KIRKLEES METROPOLITAN COUNCIL INVESTMENT & REGENERATION SERVICE

DELEGATED DECISION TO DETERMINE APPLICATIONS FOR CONSENT, AGREEMENT OR APPROVAL REQUIRED BY CONDITION

Reference No:	2022/44/93858/W
Site Address:	railway line and associated land between, Huddersfield and Westtown (Dewsbury), within the Order Limits of The Network Rail (Huddersfield to Westtown (Dewsbury), Improvements Order 2022
Description:	Discharge condition 4, 5, 6, 8,10, 19 of the Deemed Planning Permission granted by the Department for Transport in relation to The Network Rail (Huddersfield to Westtown (Dewsbury) Improvements Order 2022
Recommending Officer:	Louise Bearcroft

Discharge condition 4, 5, 6, 8,10 and 19 of the Deemed Planning Permission granted by the Department for Transport in relation to The Network Rail (Huddersfield to Westtown (Dewsbury) Improvements Order 2022

Drawing Title
TREE LOSS & RETENTION PLAN

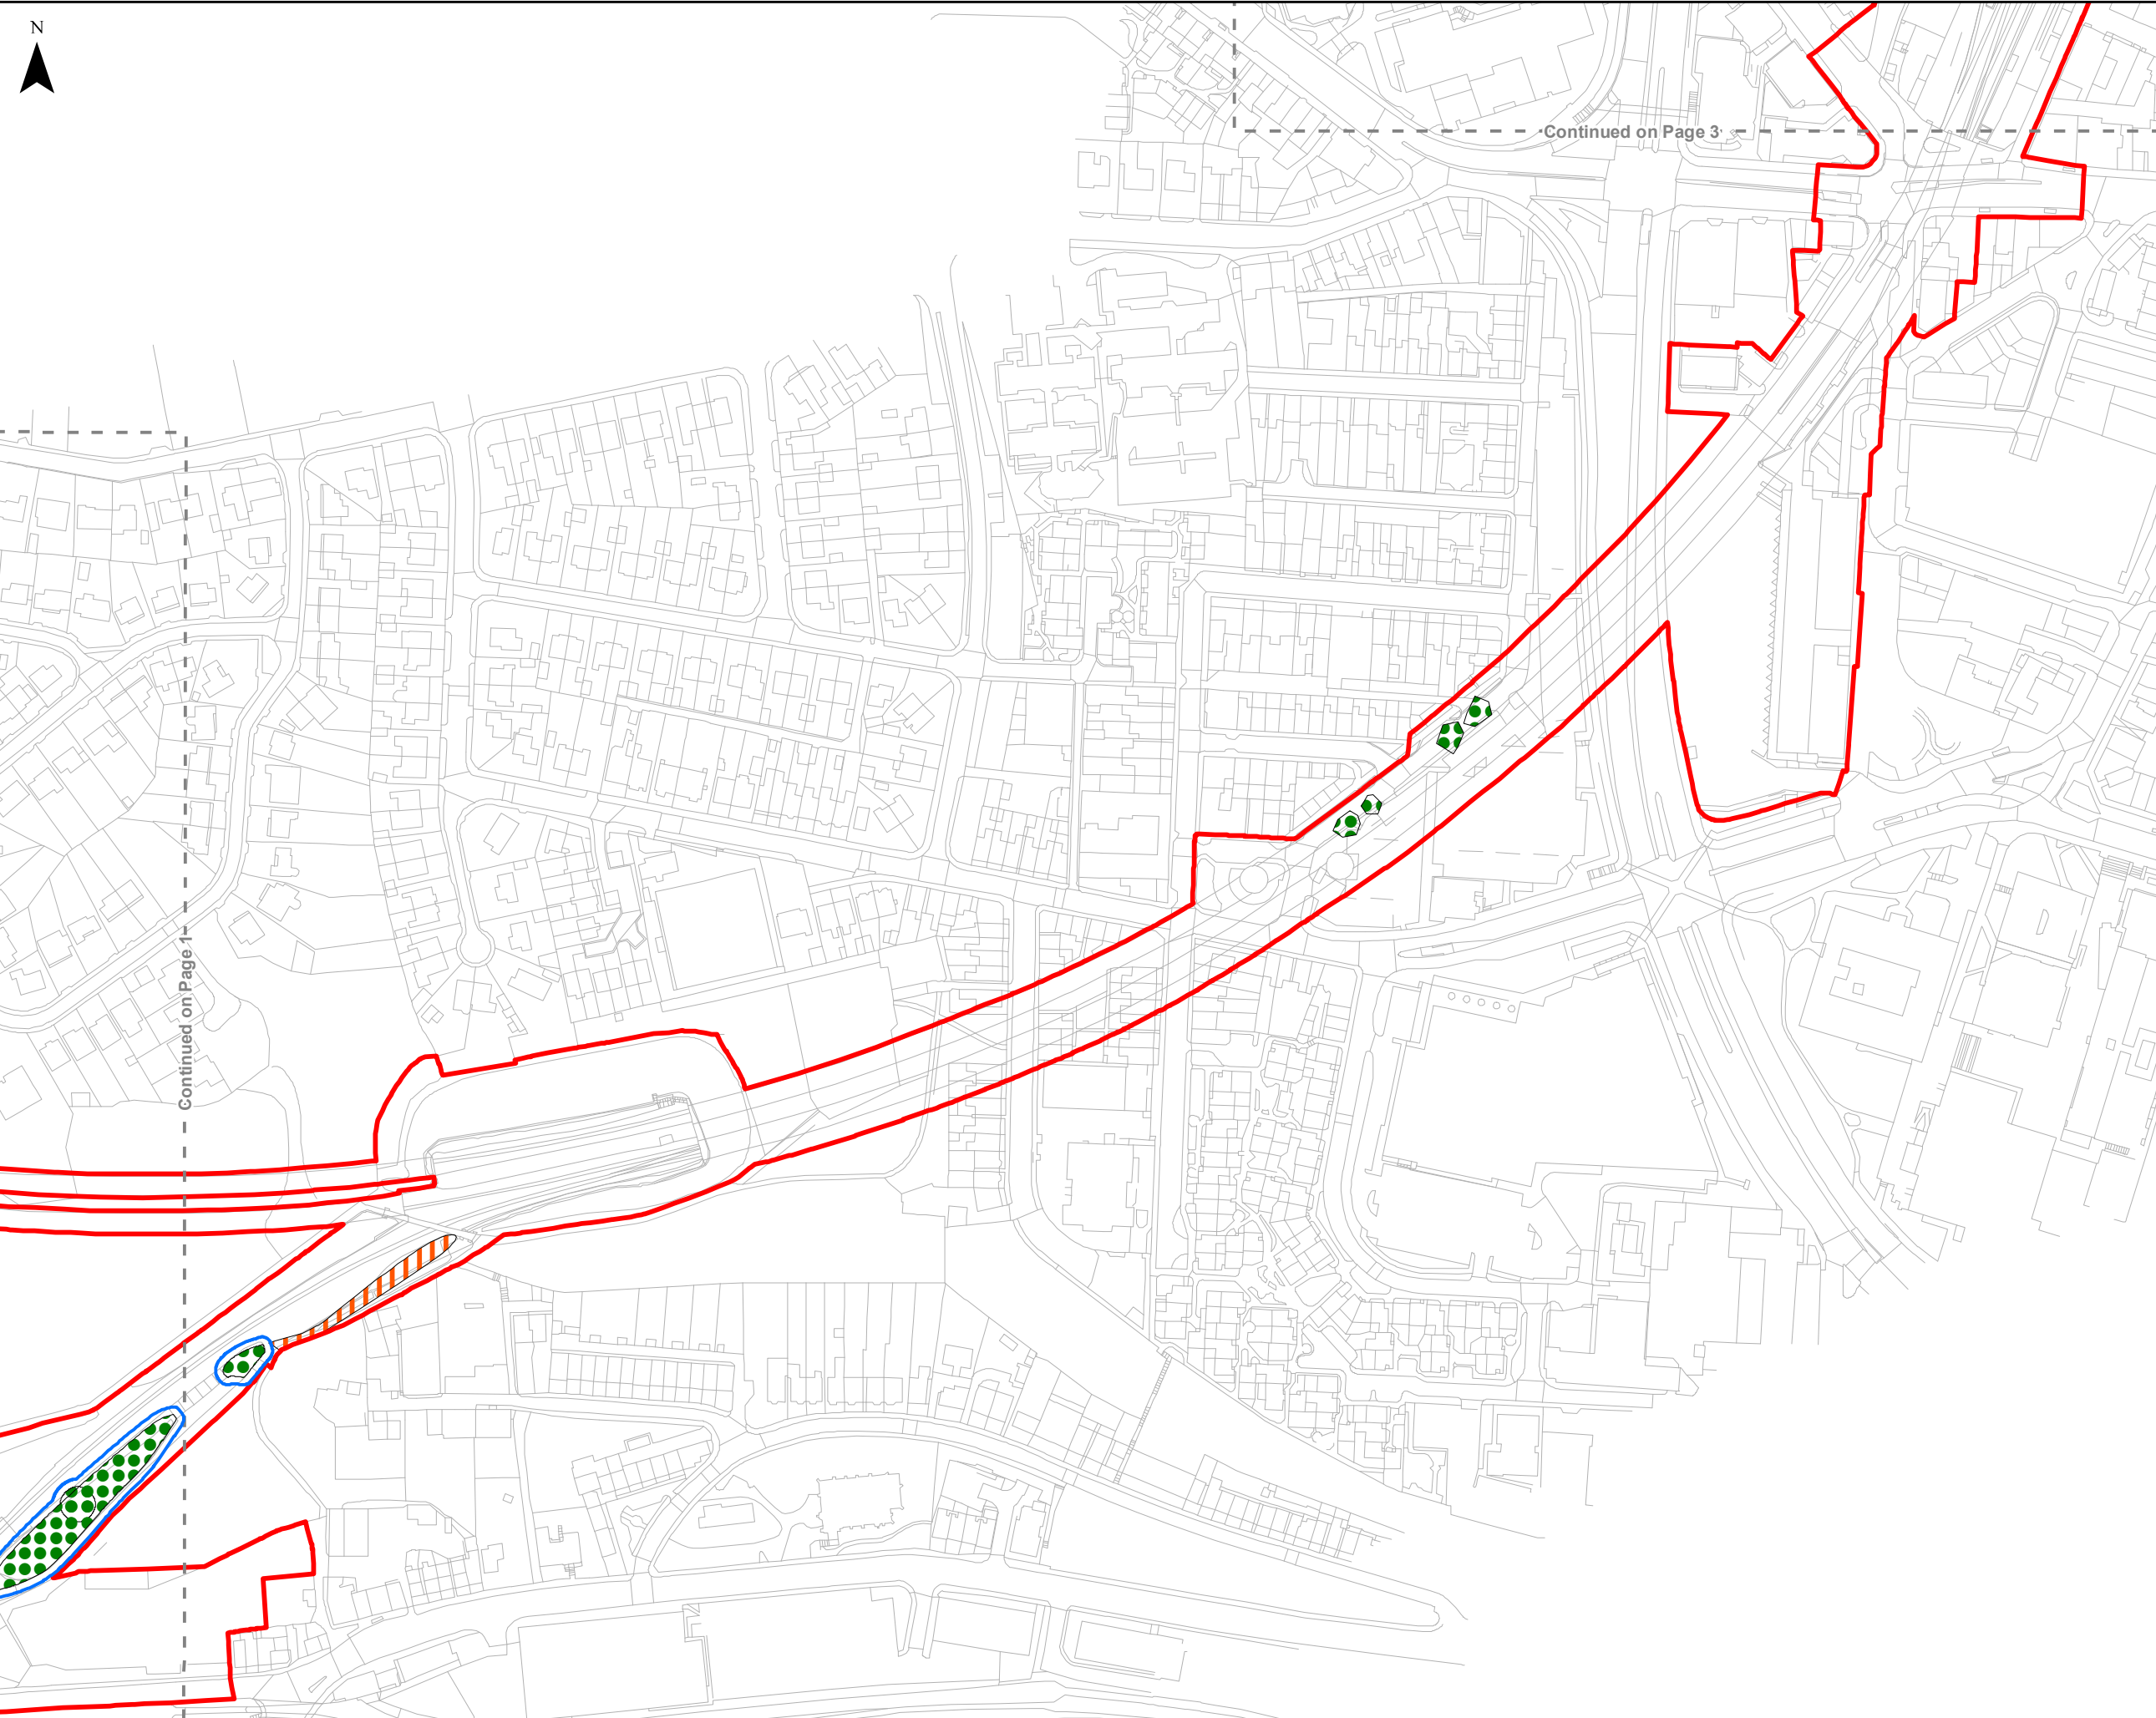
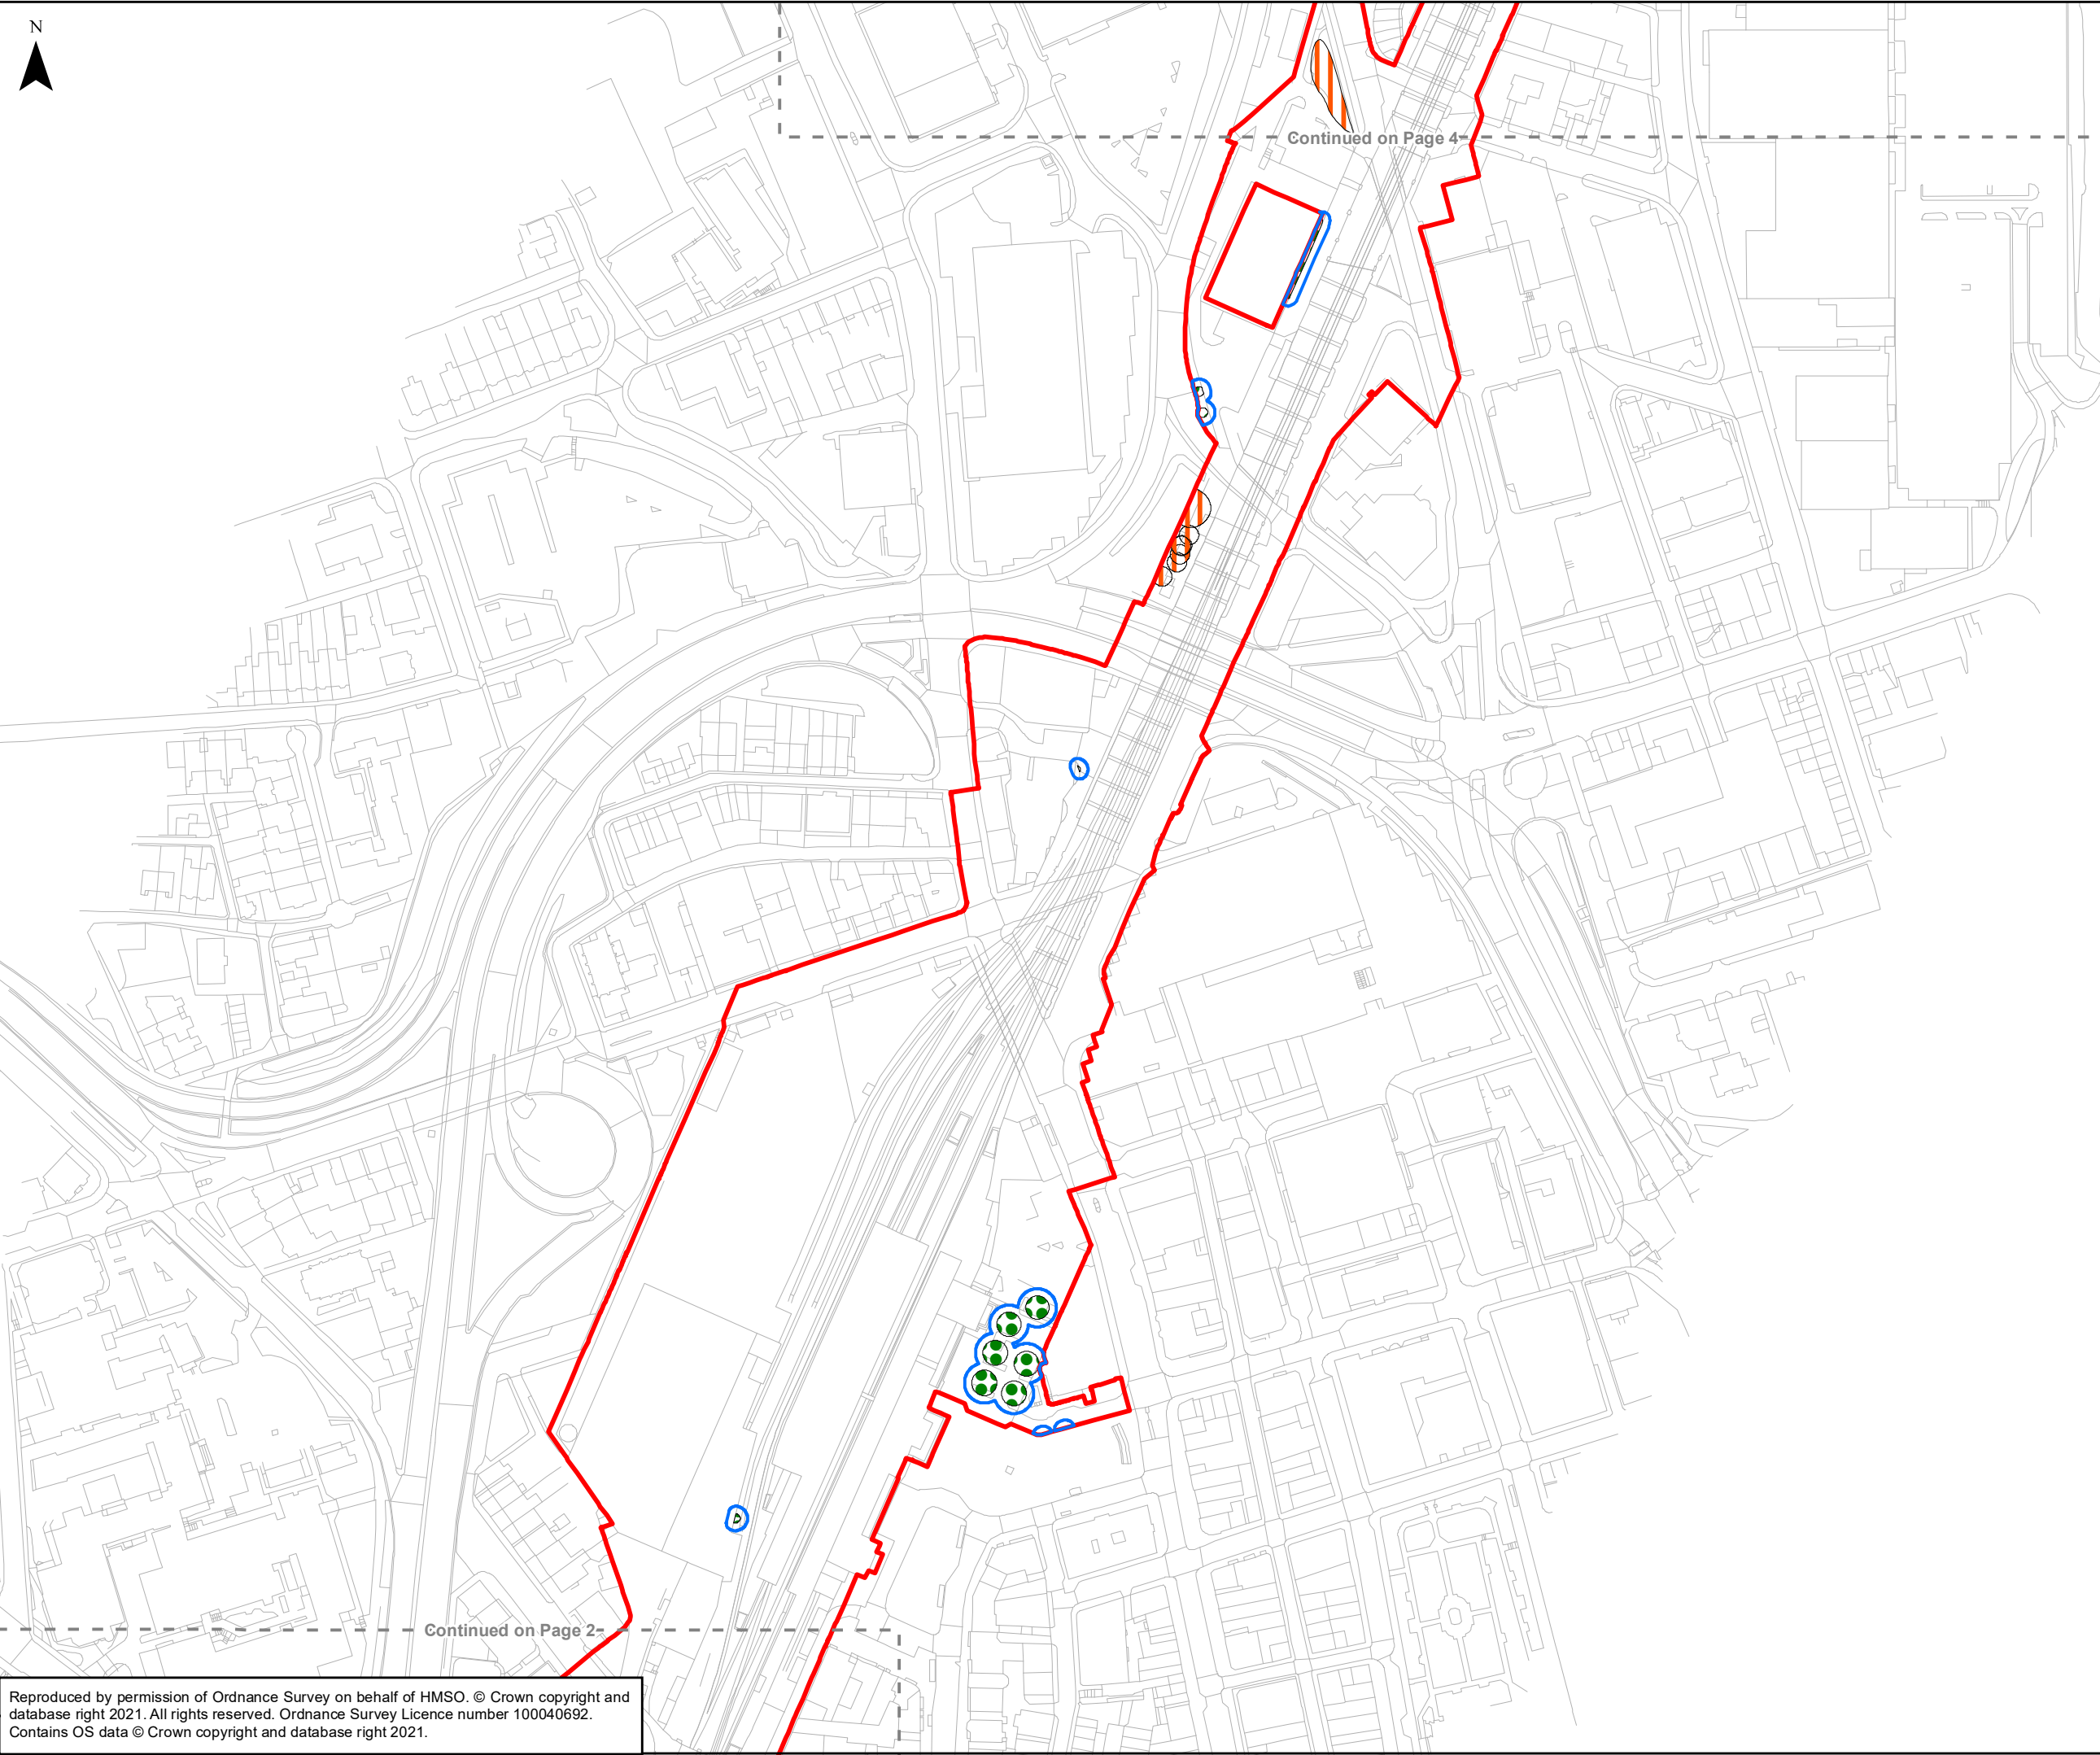
K.C Arboricultural Officer – With regards to condition 4 – Landscape and Ecological Management Plan Section 5 addresses trees to be retained on the site and trees in proximity to construction but offsite. The protection measures of installing fencing in accordance with BS5837 is in line with industry best practice and acceptable. Section 5 also states that each site will be subject to standalone Arboricultural Method Statements which will enable site specific needs to be incorporated into tree protection measures. I am satisfied that the

requirements of condition 4, with respect to tree protection, has been met by the submitted document: 151667-TSA-00-TRU-REP-W-EN-001179.

A plan of existing trees and tree features (such as groups of trees or woodland) to be retained and to be removed in accordance with BS5837 are provided and these seem to reflect the TWAO submission documents regarding tree loss (although there seems to be less tree loss around Ridings and Fieldhouse canal bridges which is welcome).

i) A plan of existing trees and tree features (such as groups of trees or woodland) to be retained and to be removed in accordance with BS5837(2012) - Section 5 details protection and mitigation for retained trees and Appendix A includes Scheme wide plans of the trees to be retained/removed shown hatched.

The aboricultural Officer notes that section 5 addresses trees to be retained on the site and trees in proximity to construction but offsite. The officer notes that the protection measures of installing fencing in accordance with BS5837 is in line with industry best practice and acceptable. Section 5 also states that

each site will be subject to standalone Arboricultural Method Statements which will enable site specific needs to be incorporated into tree protection measures. The Arboricultural officer is satisfied that the requirements of condition 4, with respect to tree protection, has been met.

Part a i) A plan of existing trees and tree features (such as groups of trees or woodland) to be retained and to be removed in accordance with BS5837(2012).
